**RE: Copper Ave Townhouse
3812 Copper Ave NE
Permanent C.O. – Not Accepted
Engineer's Stamp Date: 08/15/16
Engineer's Certification Date: 11/27/18
Hydrology File: K17D011**

Based on the Certification received 11/29/18 and site visit on 11/29/18, this certification is **not approved** in support of Permanent Release of Occupancy by Hydrology. The following comments need to be addressed for approval of the above referenced project:

ENGINEER'S SEAL	Title: Copper Ave Townhouse Condos	DRAWN BY
	GRADING AND DRAINAGE PLAN	DATE
	RHD Engineering, LLC 4305 Purple Sage Ave. NW ALBUQUERQUE, NM 87120 (505) 288-1621	SHEET #
	Richard Dourte P.E. #10854	3 of 6
		JOB #
		787485

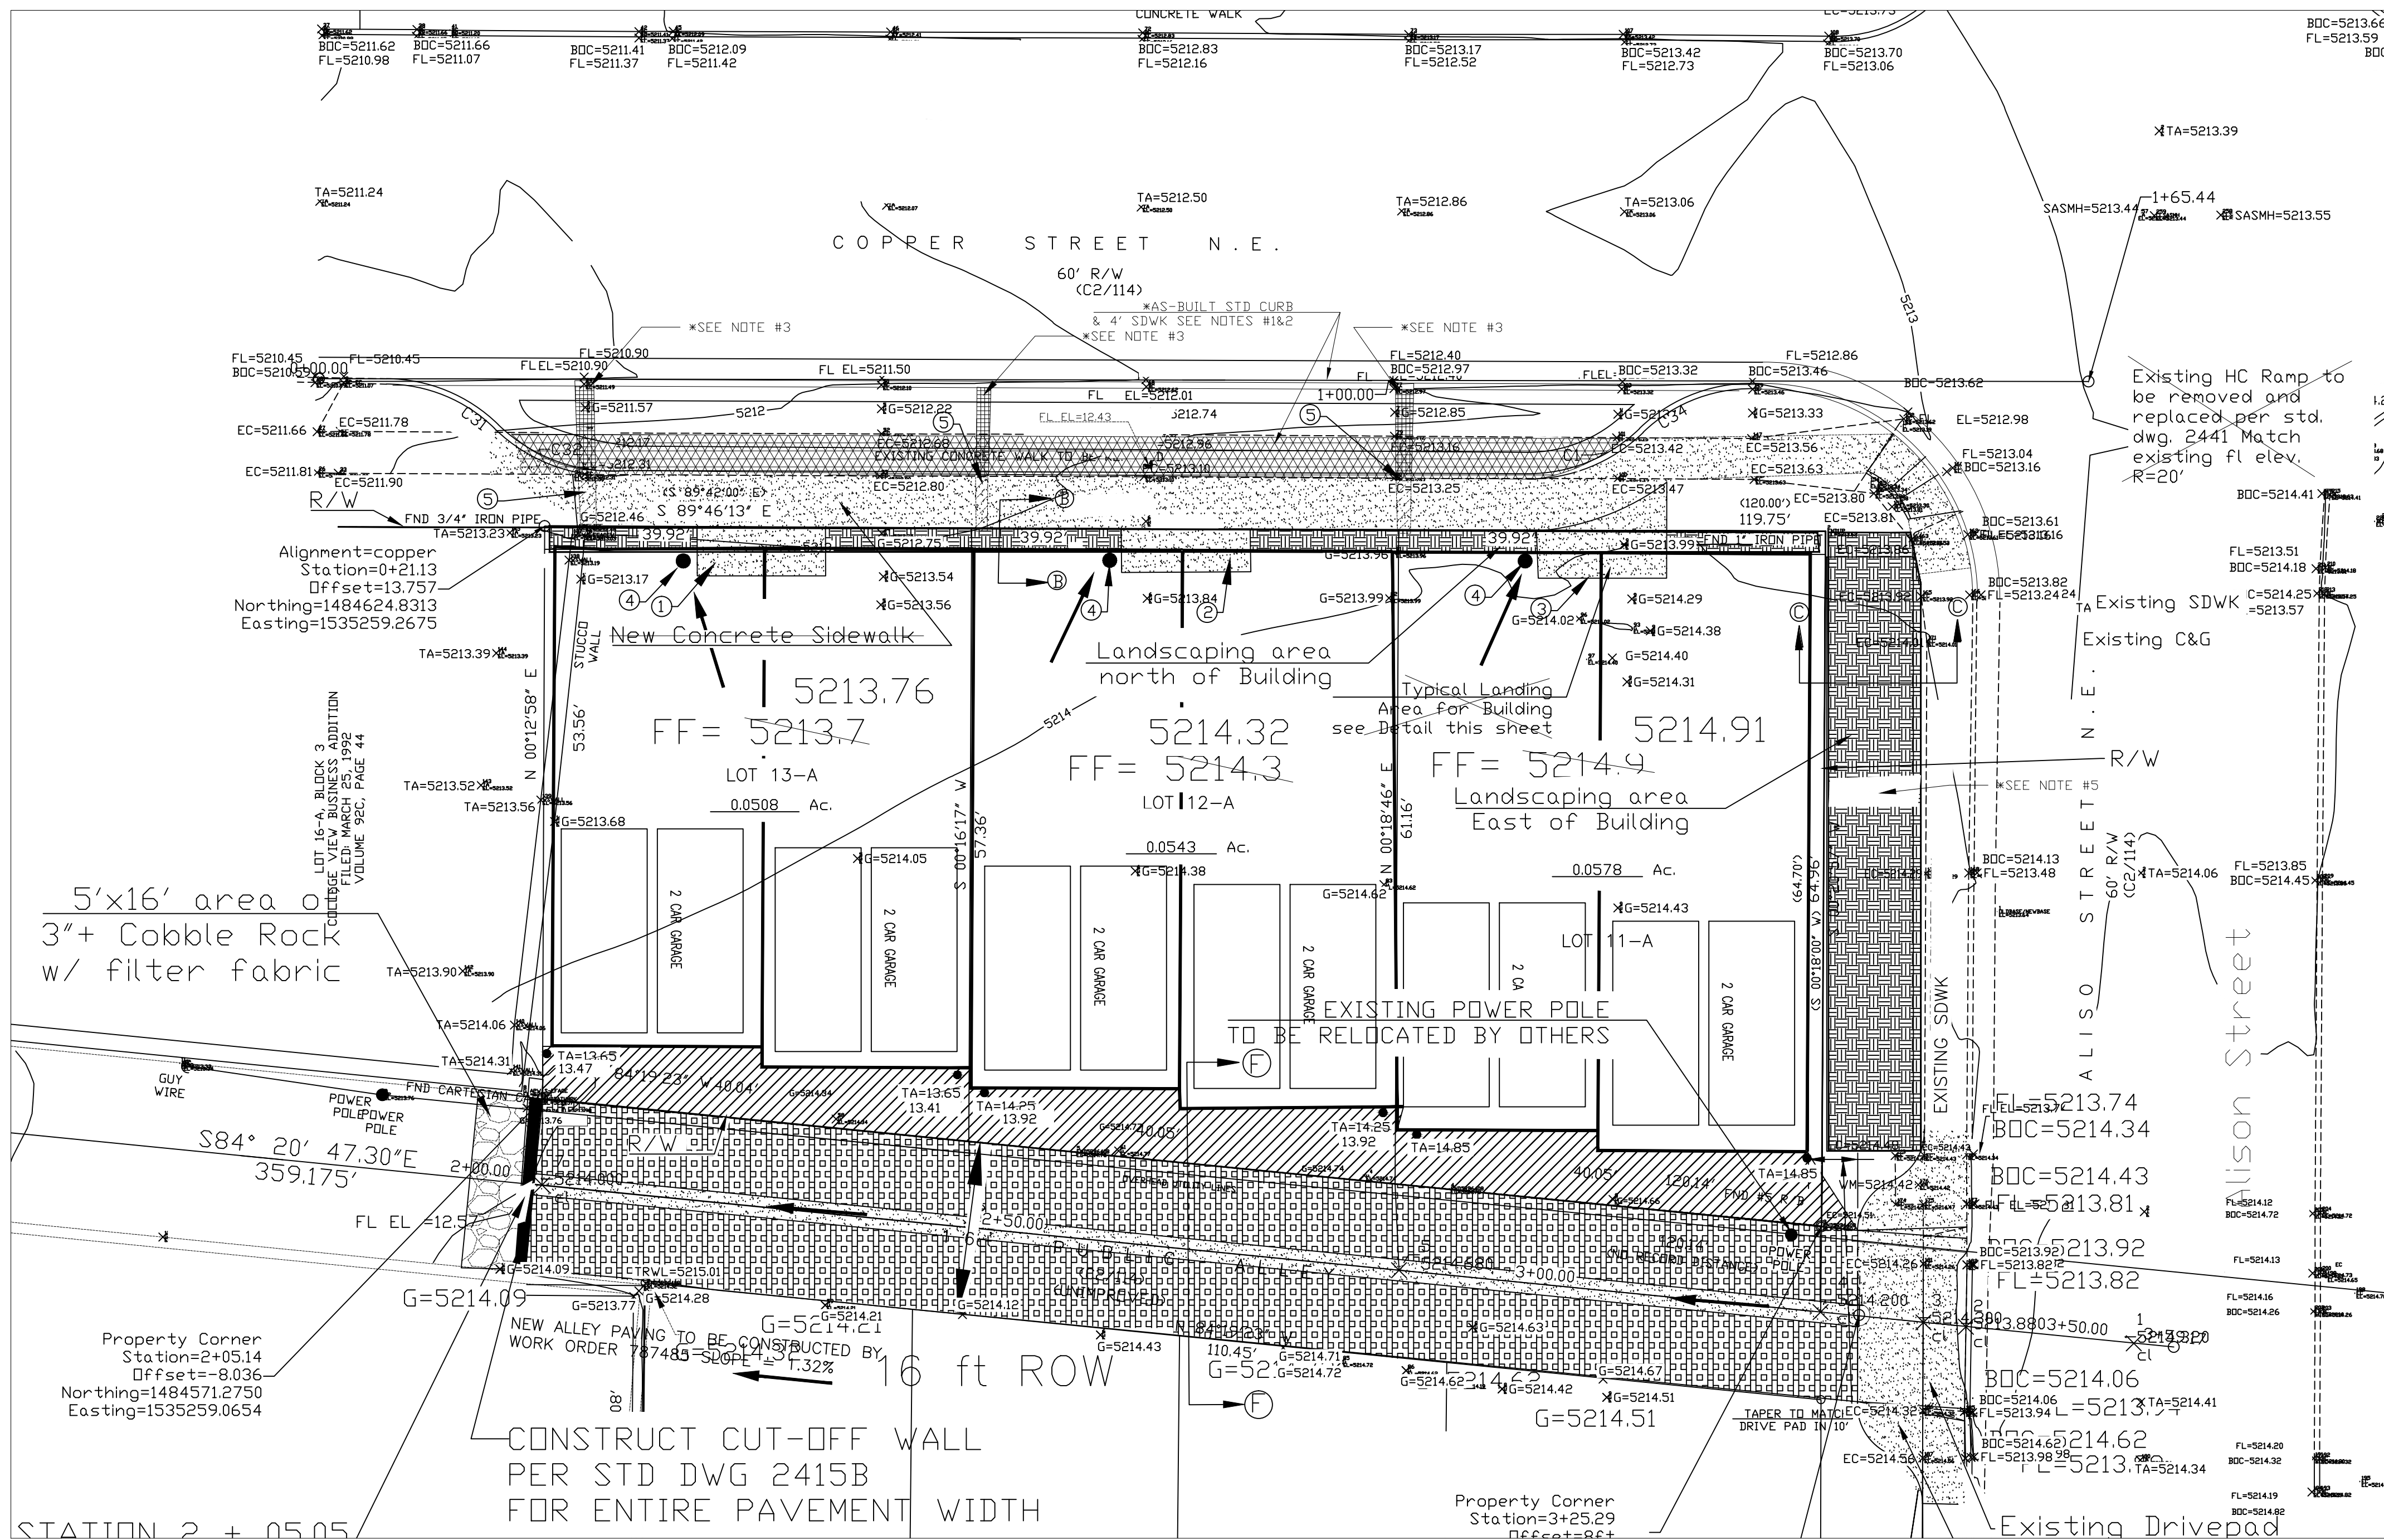
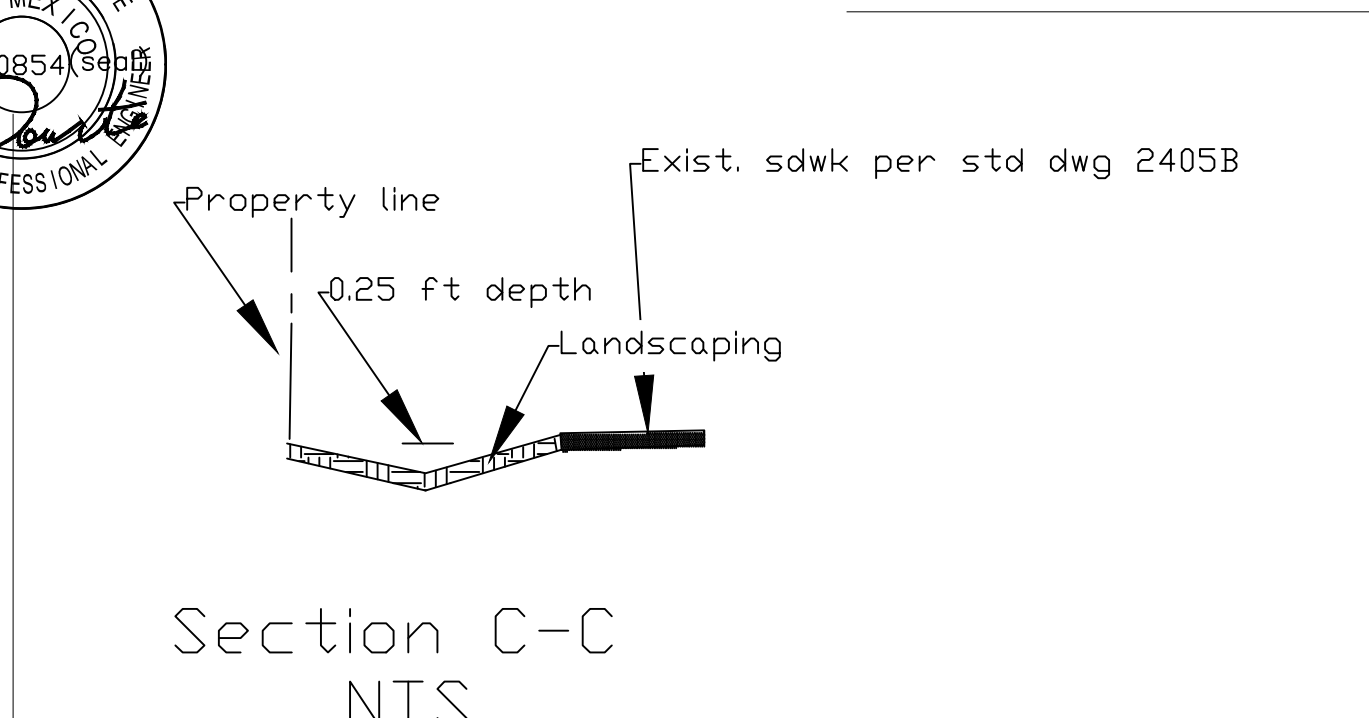
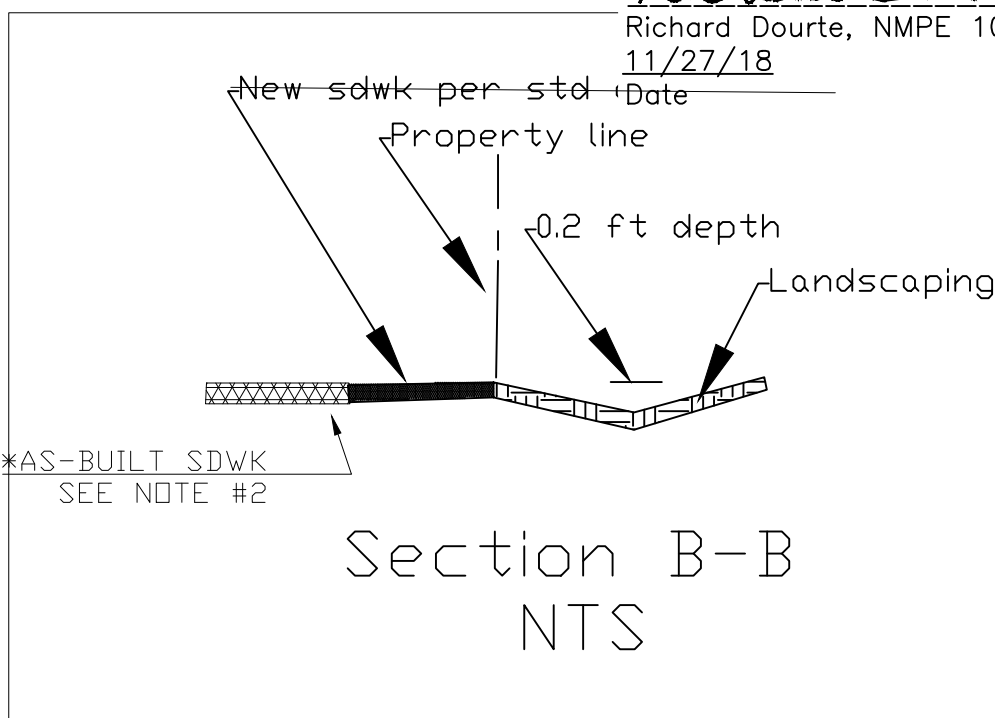
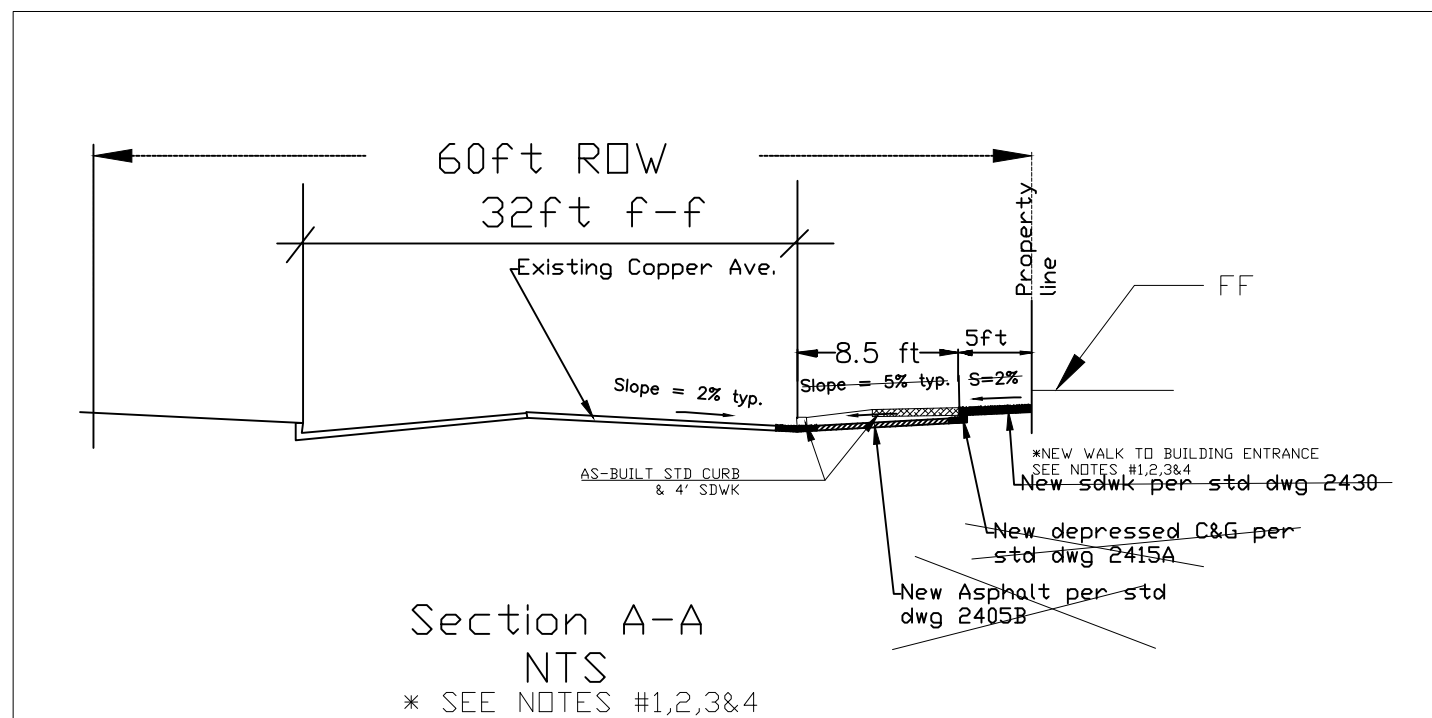
1. The punch list items for the sidewalk culverts need to be completed and accepted by Jason Rodriguez. The punch list items include the 3/4 inch bars are not on the plates and the bolt still need to be tacked.
2. Once the punch list items are complete please call Jason Rodriguez (C.O.A. Storm Maintenance) at 505-857-8607 or his Cell at 505-235-8016. Once Jason has accepted the sidewalk culverts, Hydrology will then issue an approval letter in support of Permanent Release of Occupancy.
